Ribble Valley Borough Council
Housing & Development Control

Application no: **3/2024/0333**

Address: **6 Railway View Road Clitheroe BB7 2HE**

Proposal: **Proposed dormer to rear, new ramped pedestrian access with handrail to front and alterations to front door.**

6670 - BR01D

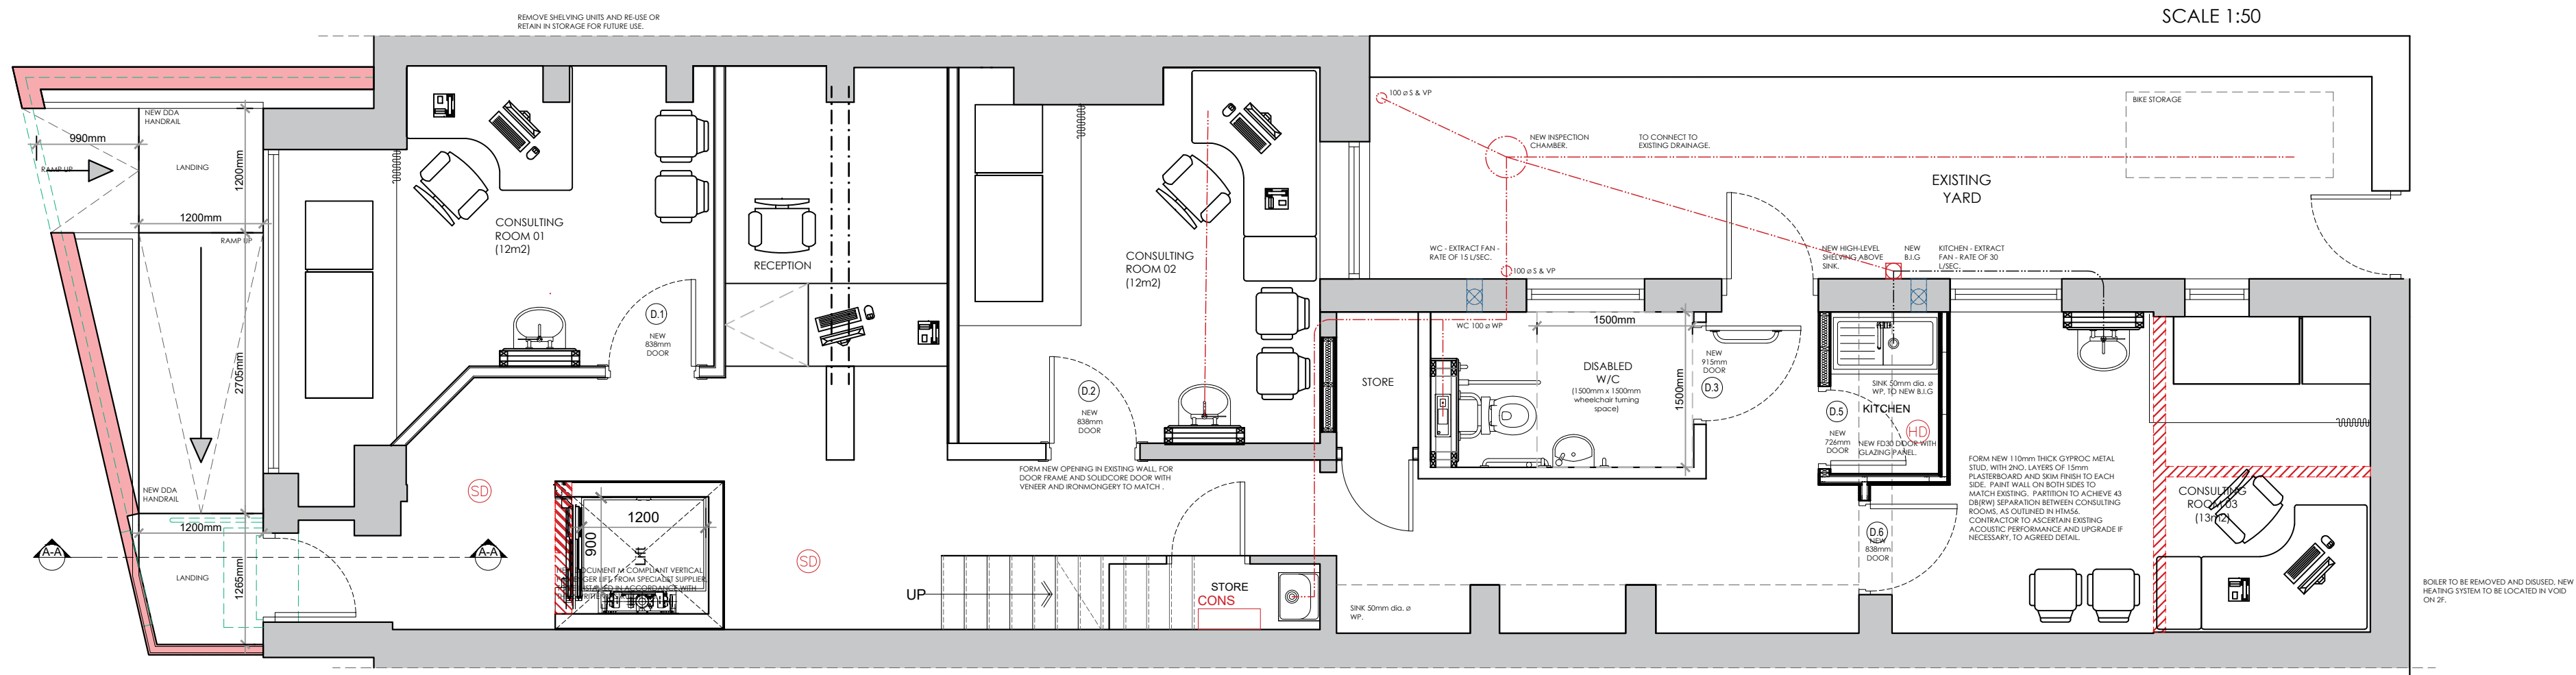
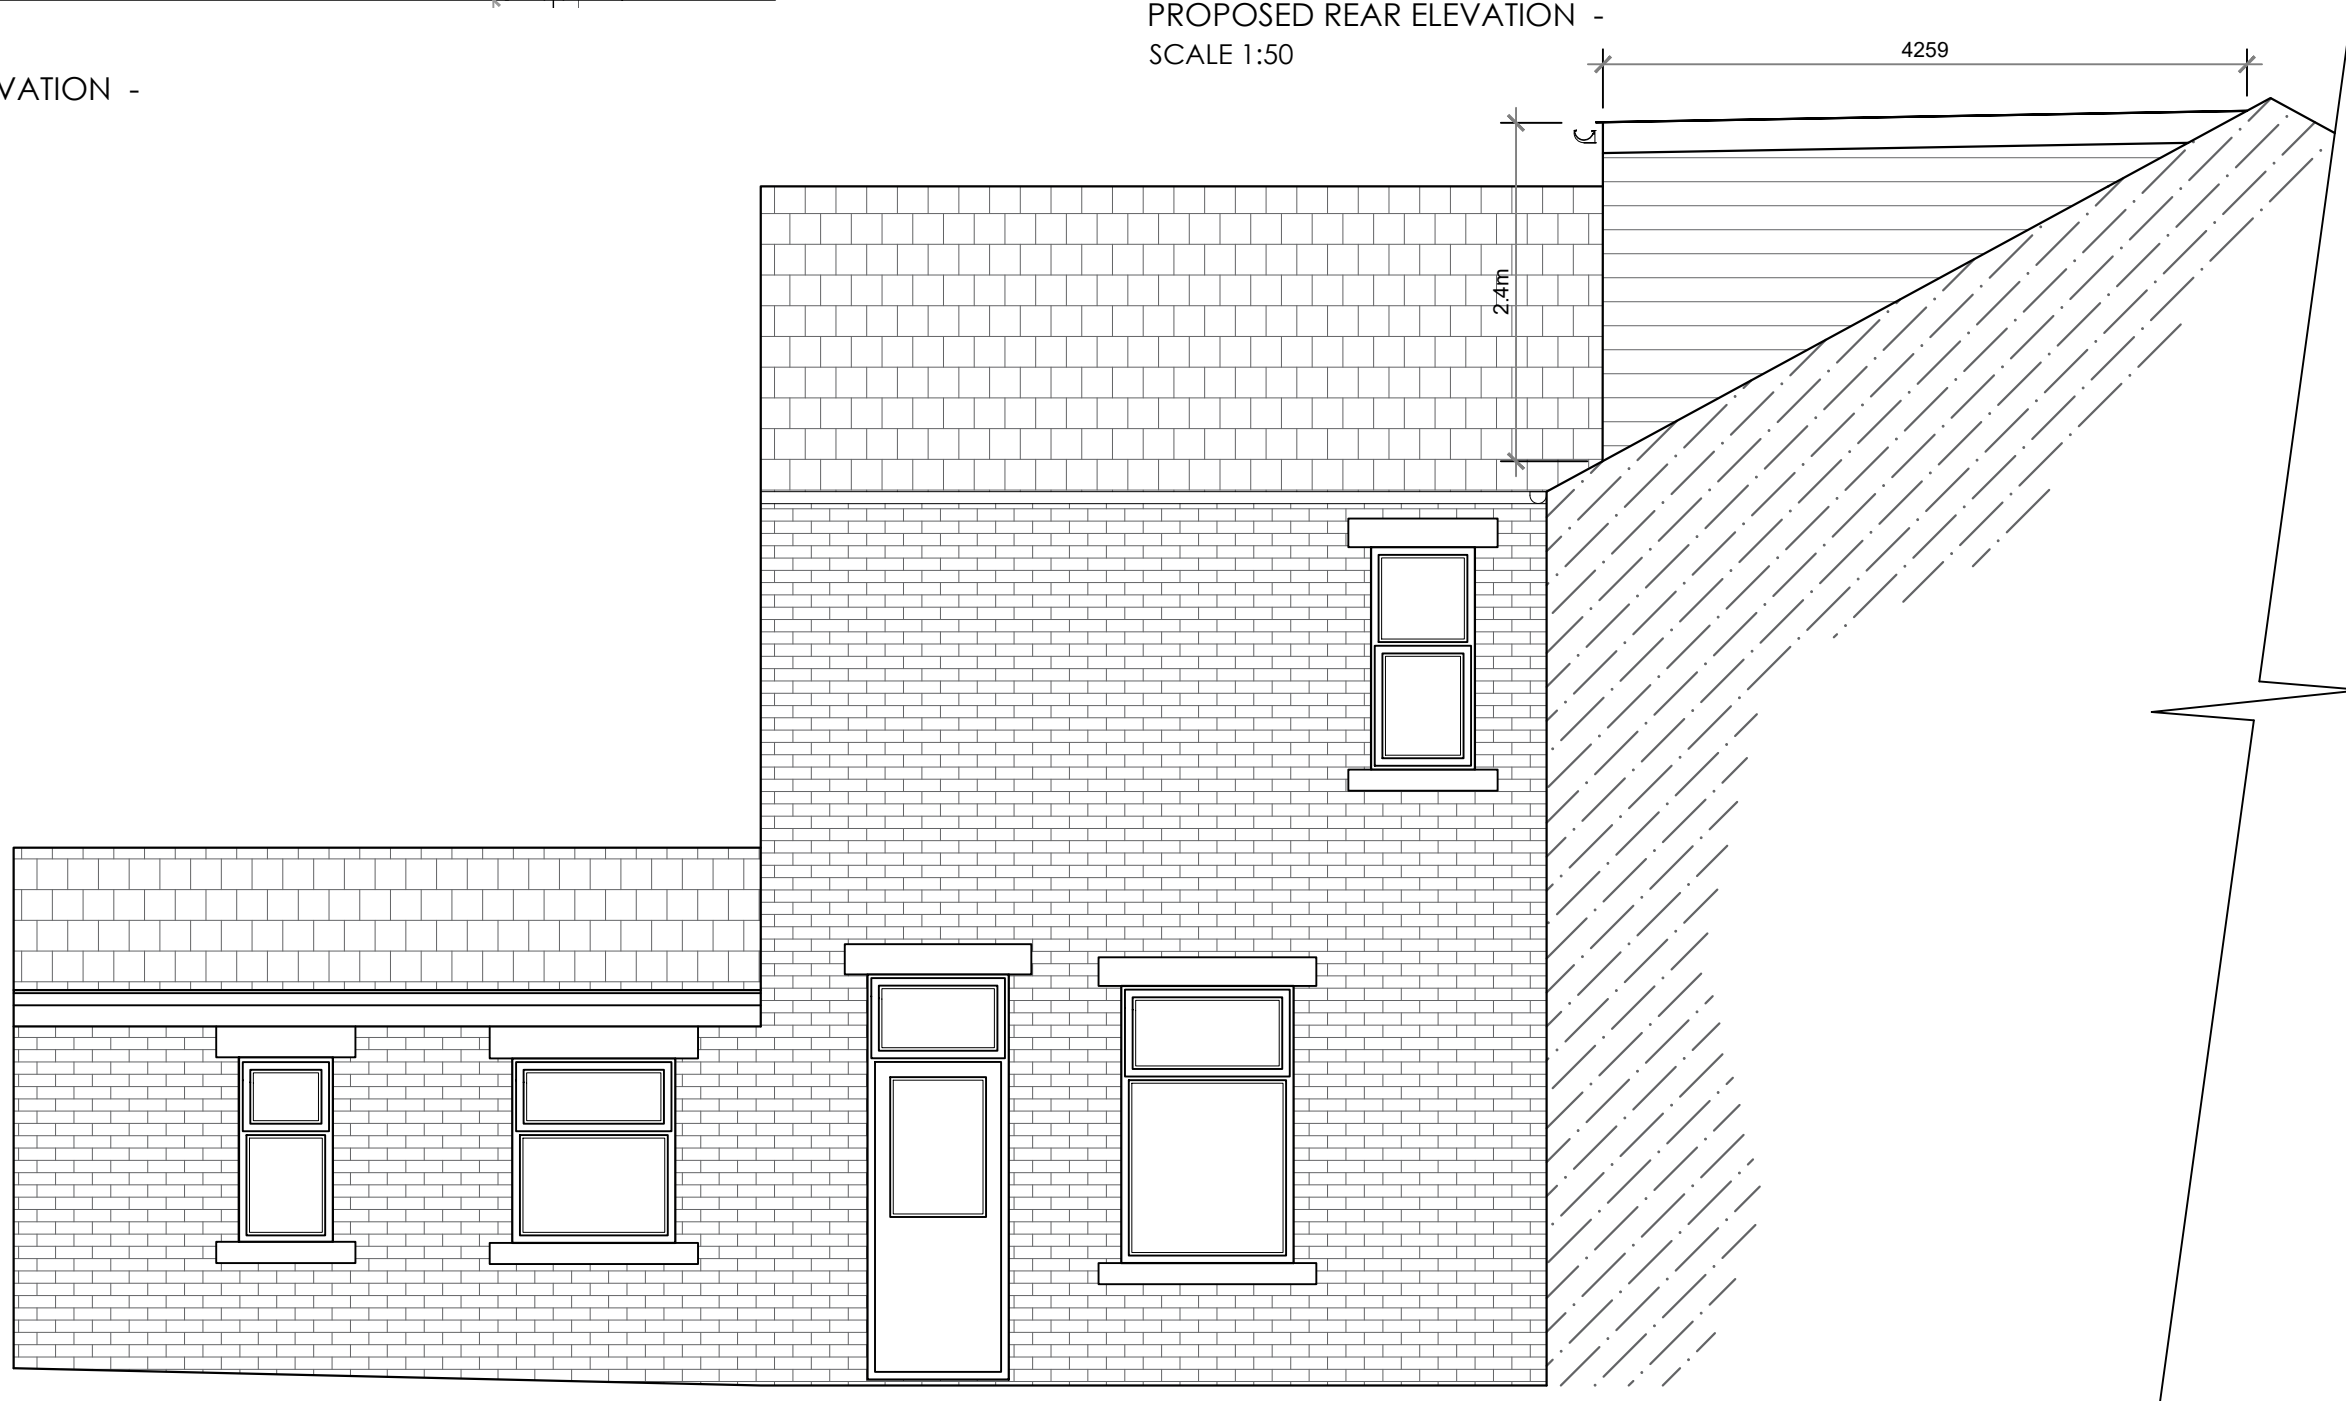
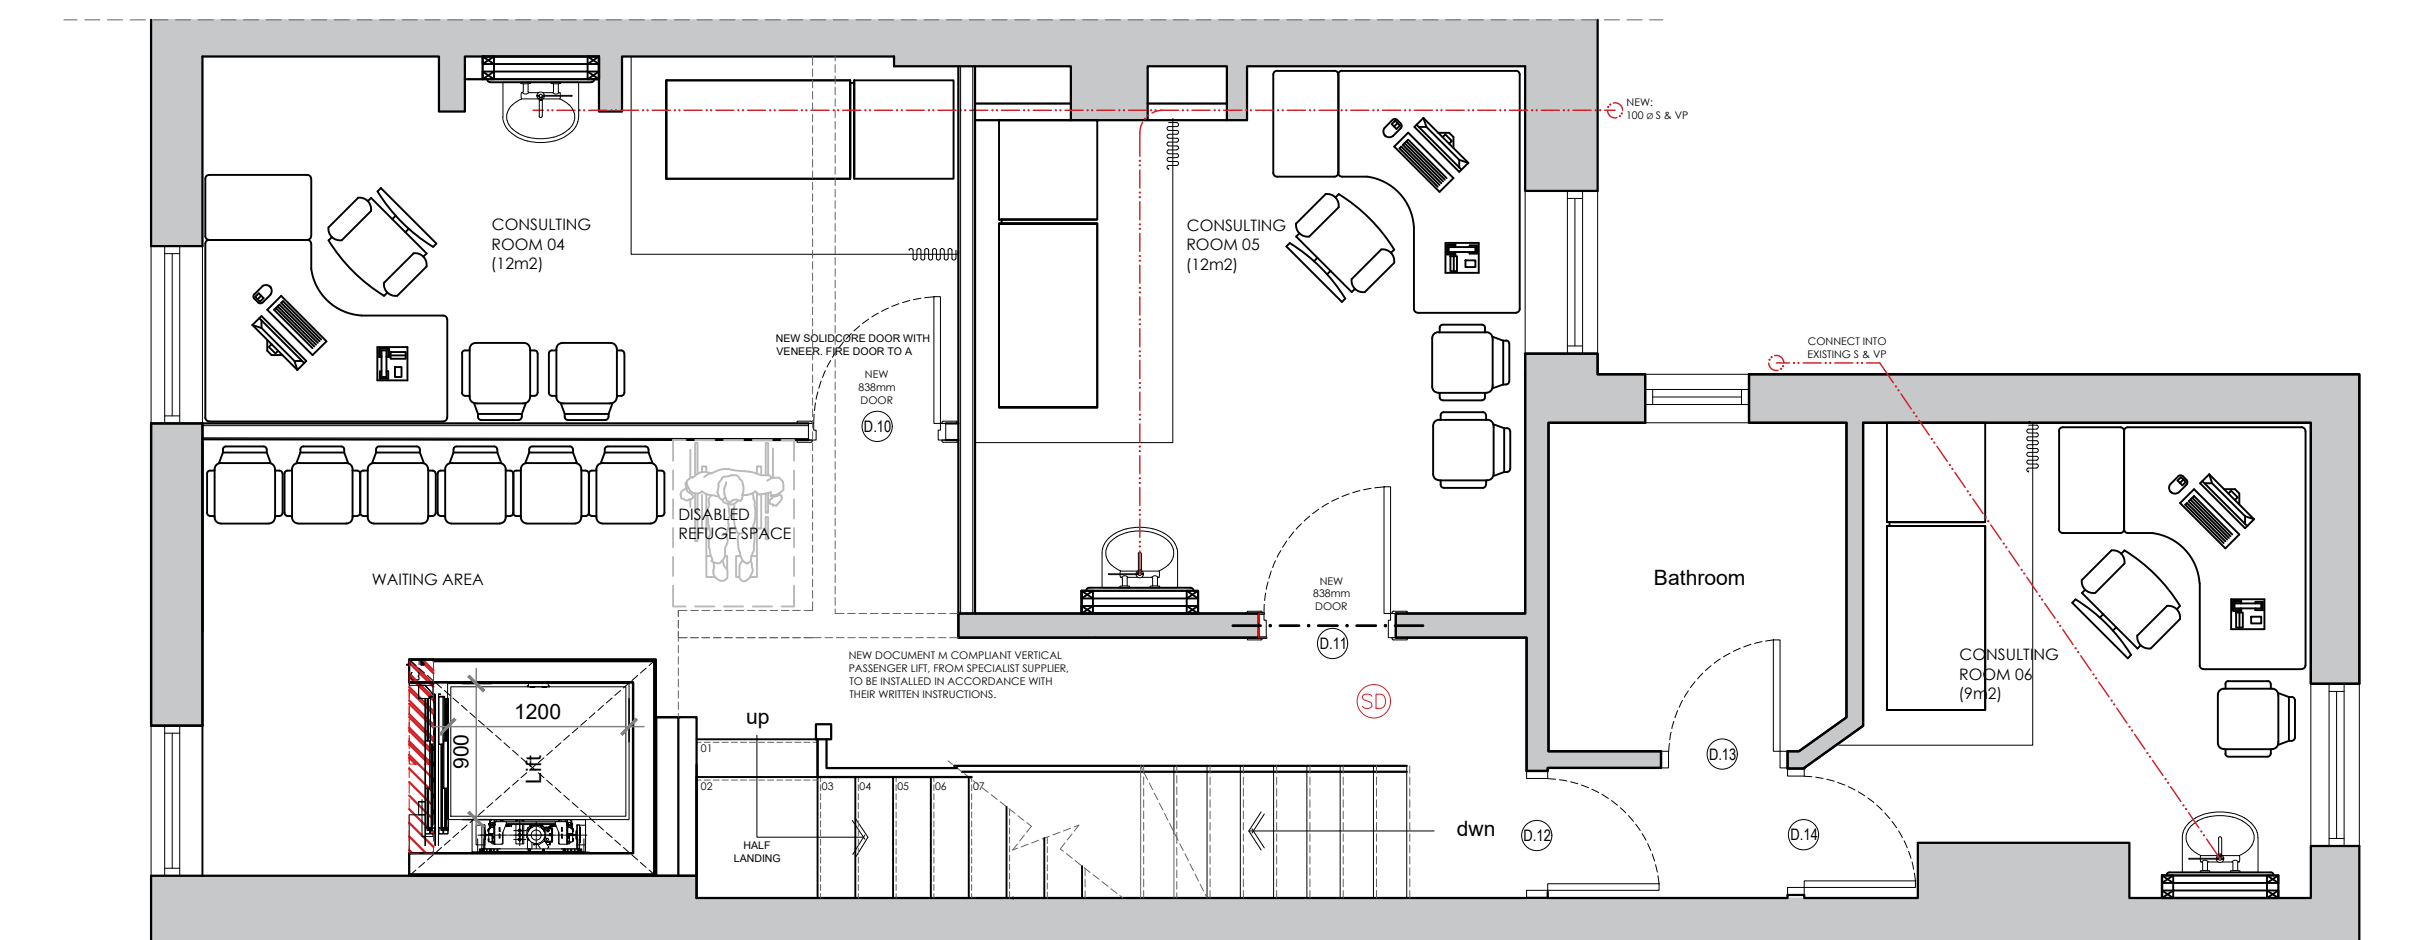
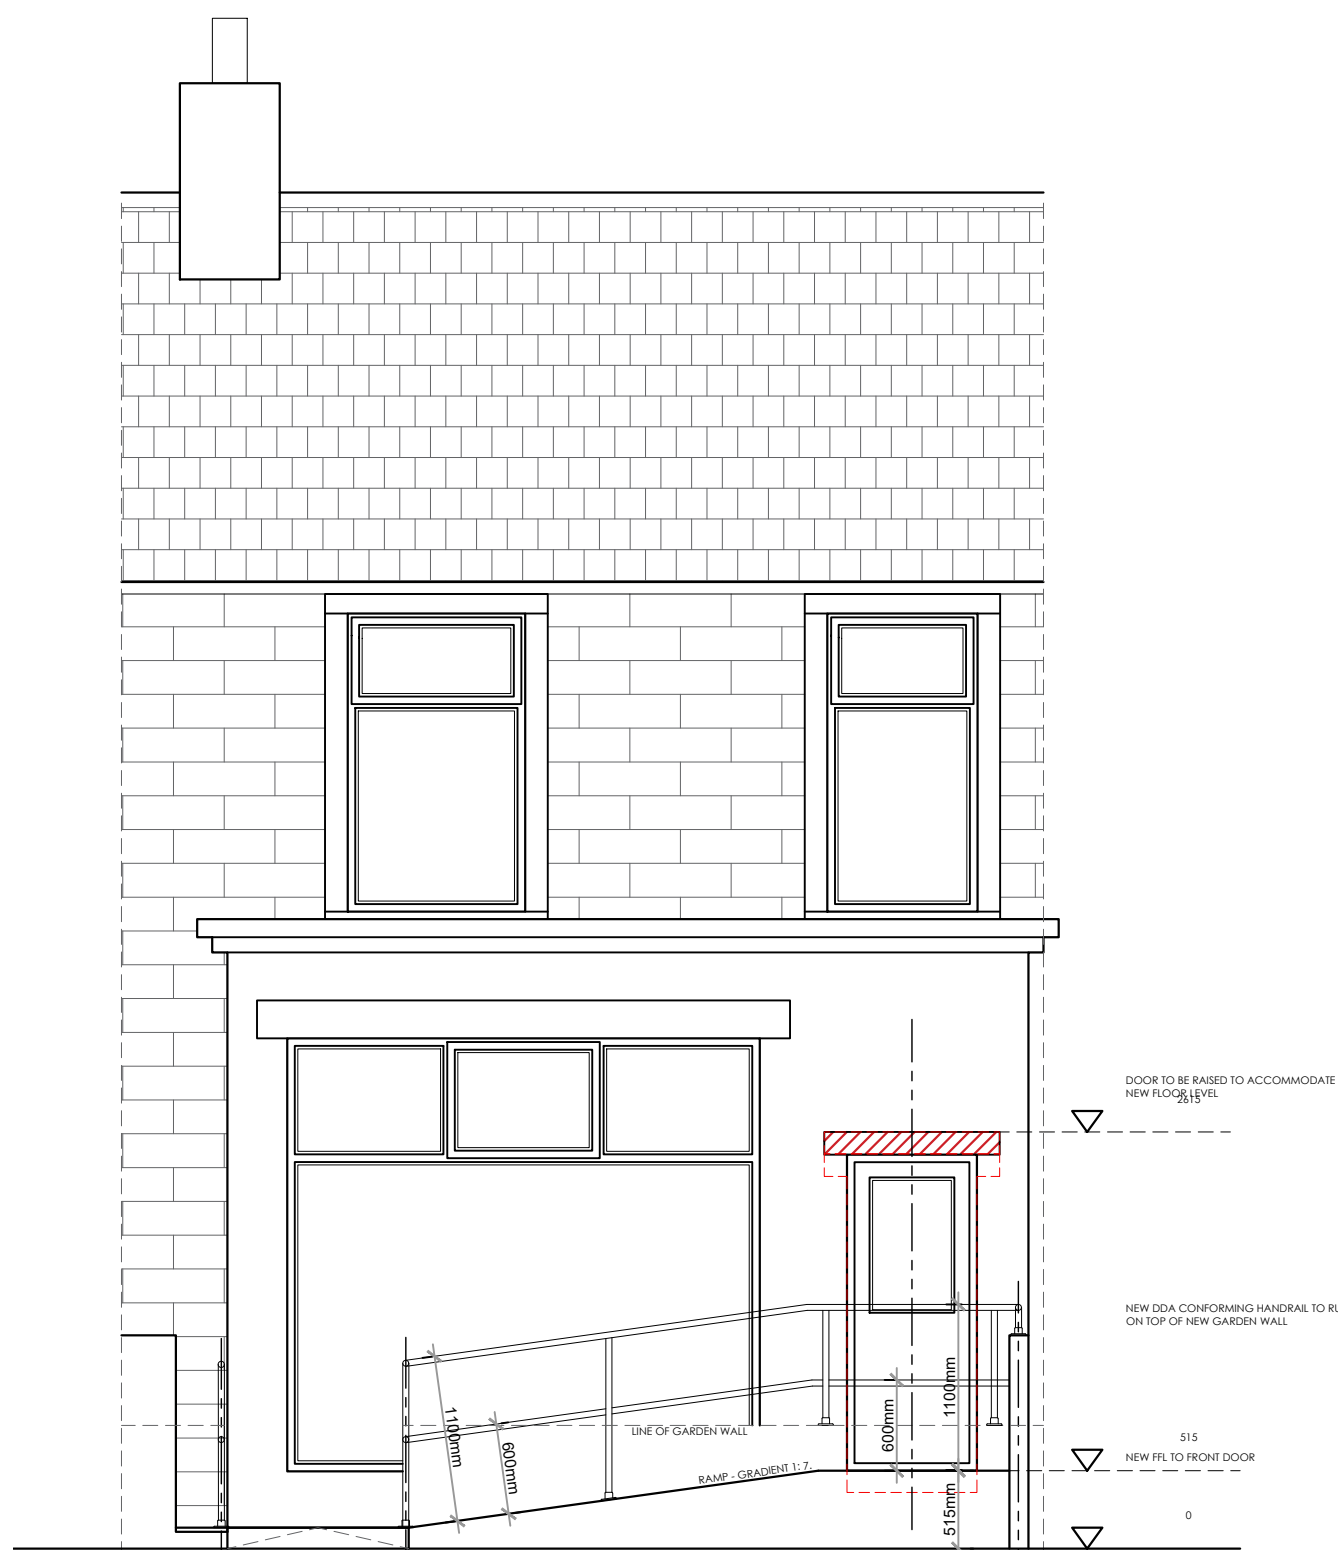
The LHA have reviewed SPA drawing number 6670-BR01D titled "Building Regs- Plans and Elevations" and note that the number of consultancy rooms will increase from 2 to 8. For the site to fully comply with the LHAs parking guidance as defined within the Joint Lancashire Structure Plan, the LHA require the site to provide 32 car parking spaces. However, the site is unable to provide any.

Despite this, the LHA will accept any shortfall in parking at the site. This is because the site is located in a sustainable location in the centre of Clitheroe where patients and staff members can take advantage of the various bus and train services which occur at regular intervals throughout the day, with the public transport interchange for Clitheroe being located approximately 180m away.
